**Hinckley & Bosworth Borough Council**  
**Interested Party Reference Number: 20039546**

**Deadline 3 Submission:**  
**Response to Local Impact Report Comments**

**Application by Tritax Symmetry (Hinckley) Limited for an  
Order Granting Development Consent for the Hinckley  
National Rail Freight Interchange**

**(ref. TR050007)**

Figure 11.12: Night-time Views and Photomontages PVP 25

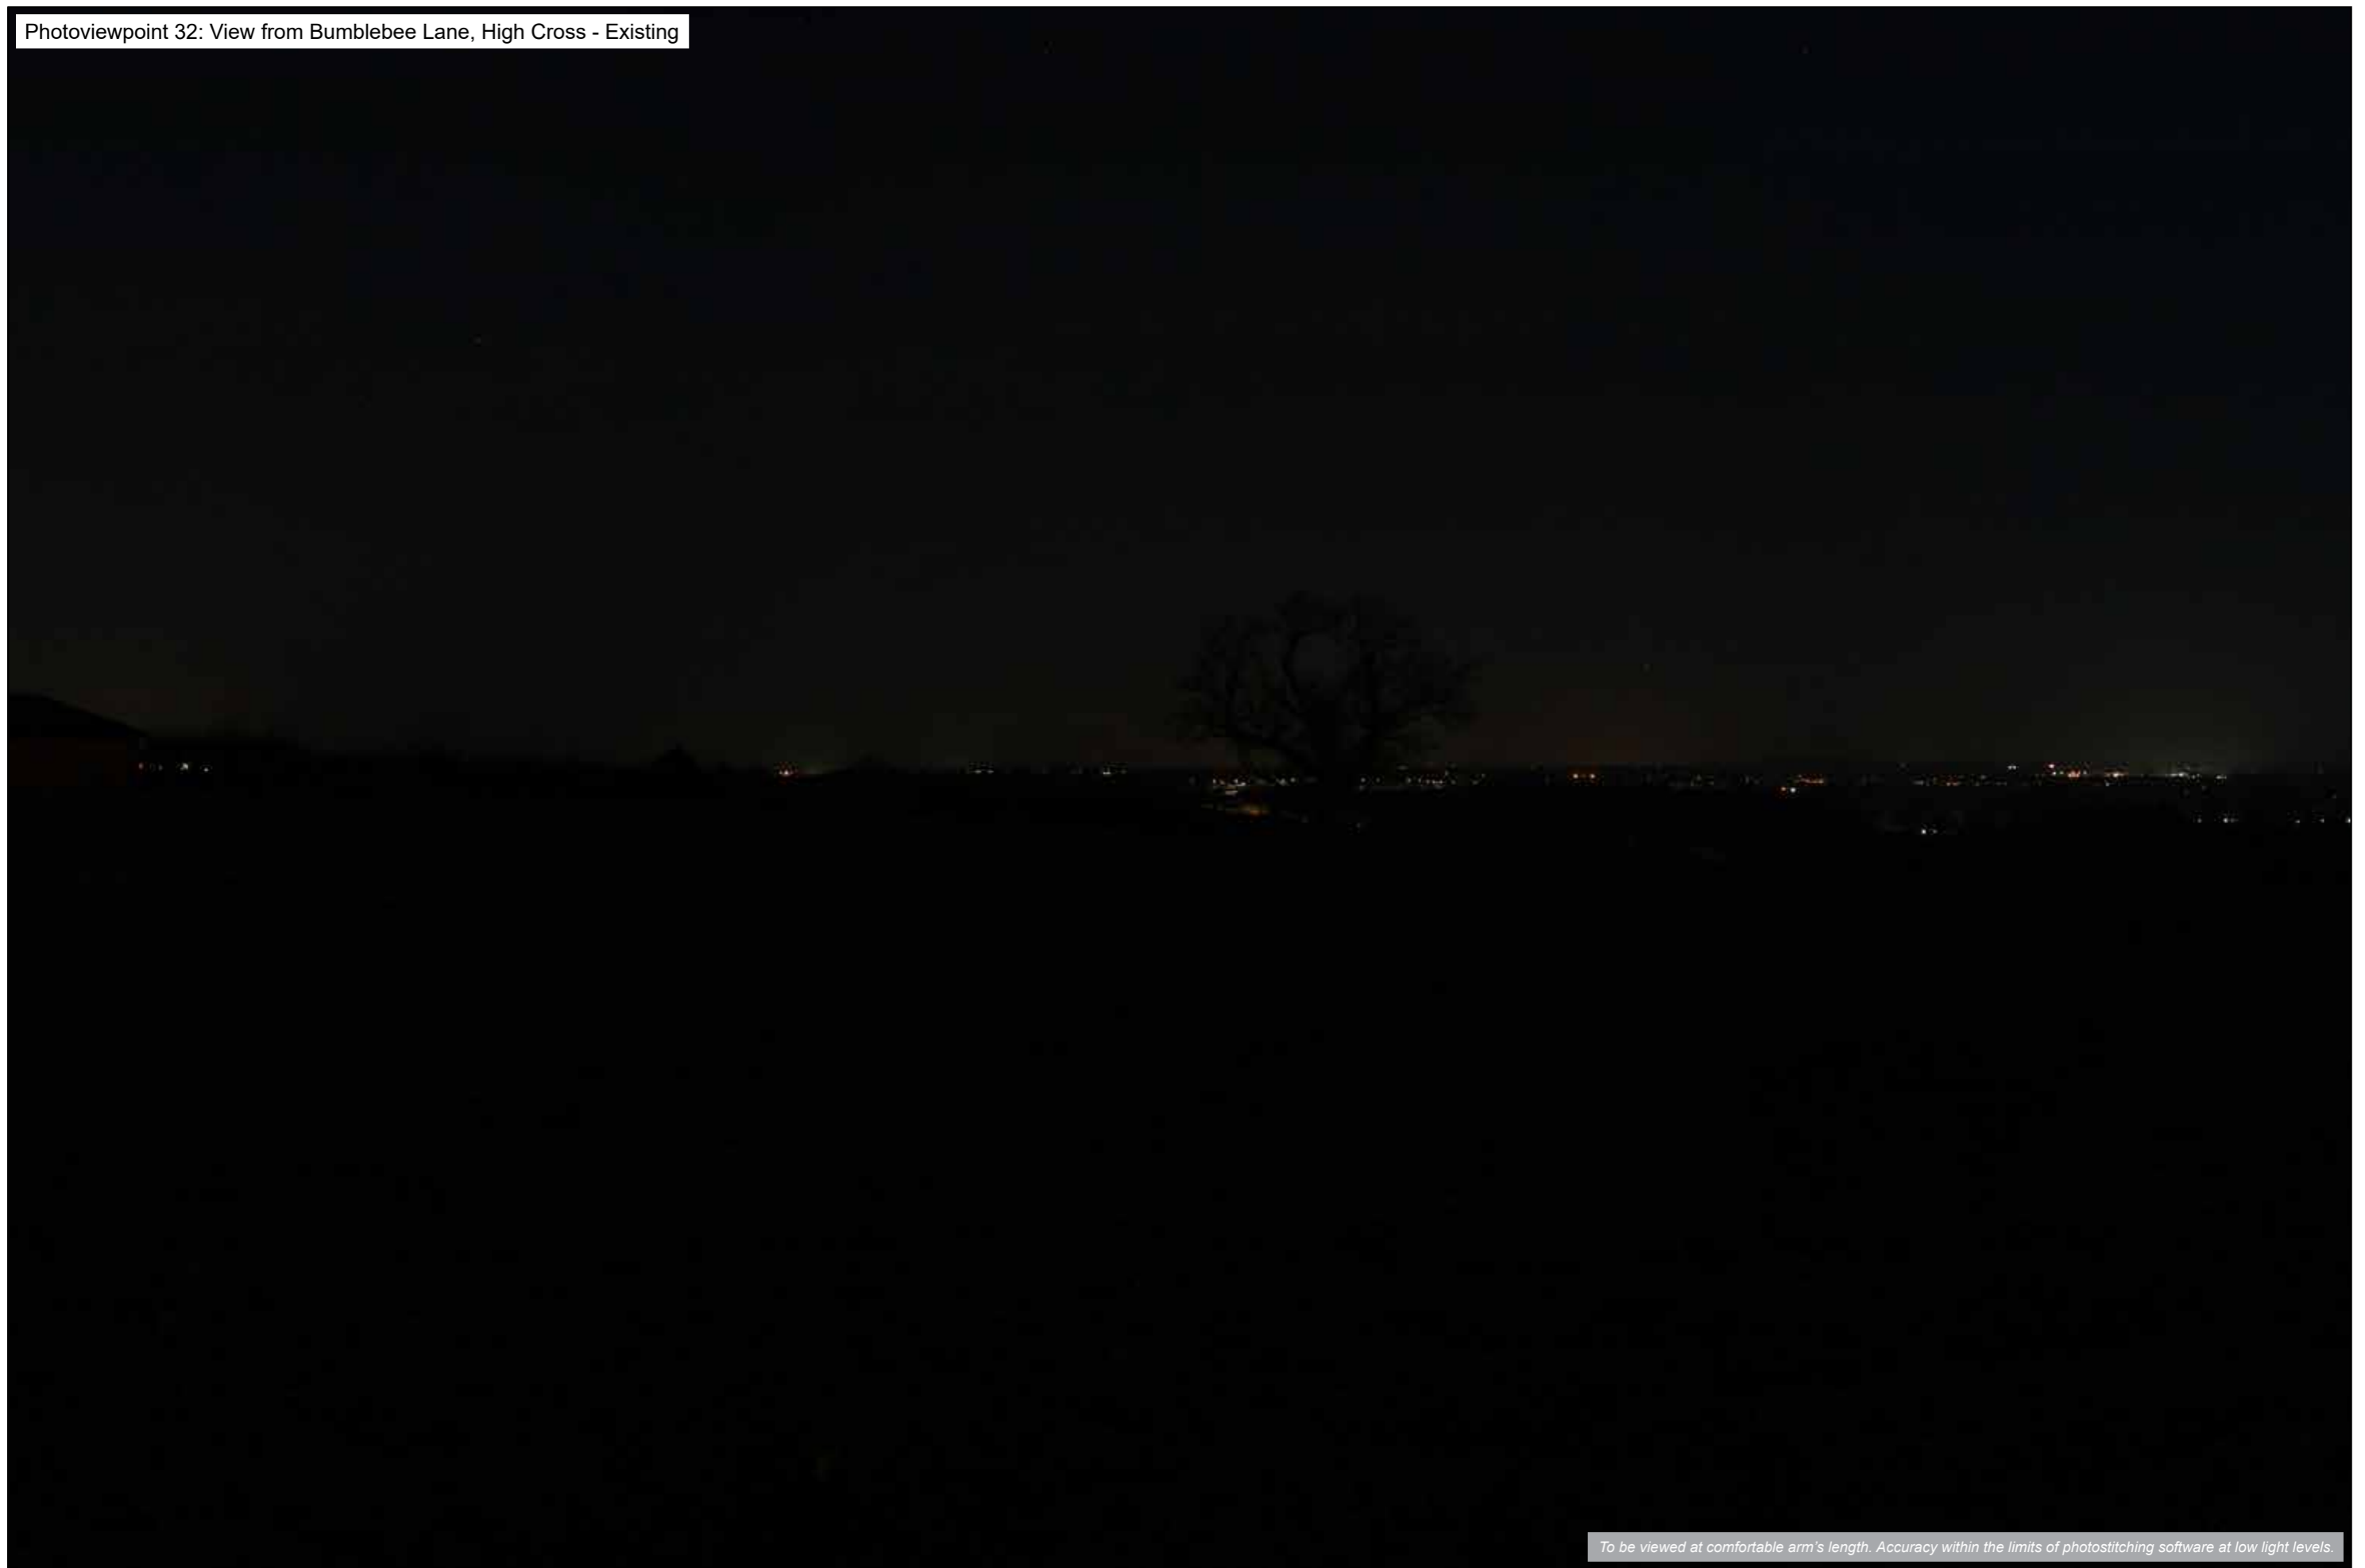
<p>views from surrounding higher land. Views from Barwell and Earl Shilton highlighted as being impacted in the middle ground views. Views from Elmesthorpe highlighted as dominating the backdrop to the village.</p>	<p>obtained across the Vale. As illustrated in Proposed Photomontages PVP 25 and PVP26, (document reference: 6.3.11.16, APP-300) whilst the development will be visible, there remain longer views beyond the development, maintaining a sense of perspective. These are assessed as part of ES Chapter 11 (document reference 6.1.11, APP-120) and agreed in the SoCG.</p> <p>Views from Elmesthorpe are largely well contained by built form and vegetation. Photomontages PVP19, 53, 48, 49 and 50 illustrate the locations where the development will be visible and these are assessed as part of ES Chapter 11 (document reference: 6.1.11, AS- 025) and agreed in the SoCG</p>	<p>Elmesthorpe is located on a low ridge and its linear form means that it has a physical and visual relationship with the surrounding landscape. Whilst not captured by the agreed PVP locations, there are locations along Station Road from where glimpsed views are available between properties across the surrounding open farmland. The introduction of the proposed development would fundamentally alter the rural character of the village, as demonstrated by the residual significant effect reported for PVP 19, 49 and 50 (as agreed within the draft Landscape SoCG).</p>
